Our Ref: 23/02271/FULL

Application No: 23/02271/FULL
Proposal: Erection of workshop for car valeting (sui generis)
Address: Brenwood Suzuki Mitchelston Industrial Estate Waverley
Road Kirkcaldy Fife

PROJECT
Erection of steel frame structure for valeting of vehicles
DRAWING TITLE
Proposed Site Layout

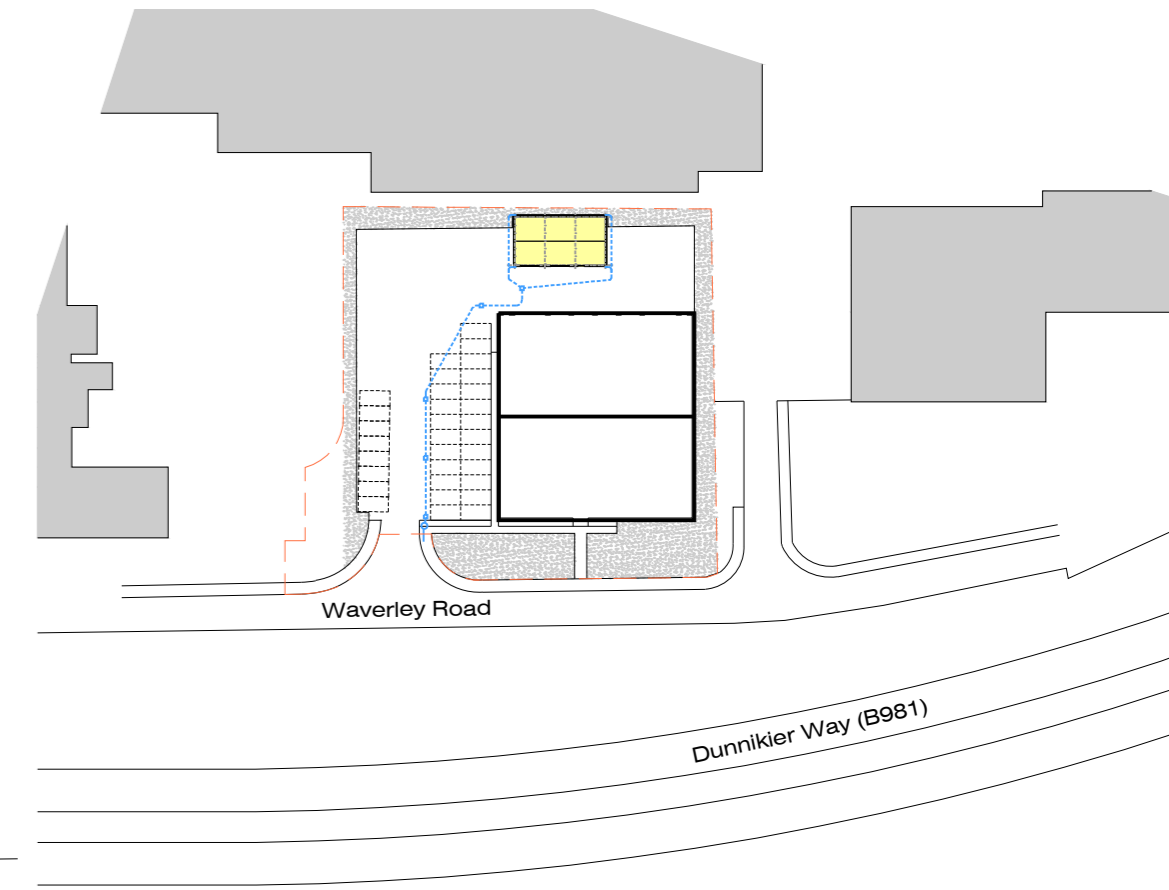
1. Although there may be existing drainage on site for the existing building the introduction of a new building may create issues in relation to surface water management. It is noted that you have indicated how the building would connect to the existing drainage layout, however there is a requirement to provide further detailed information on SUDS, including calculations, along with details of treatments to be submitted as part of this planning application.
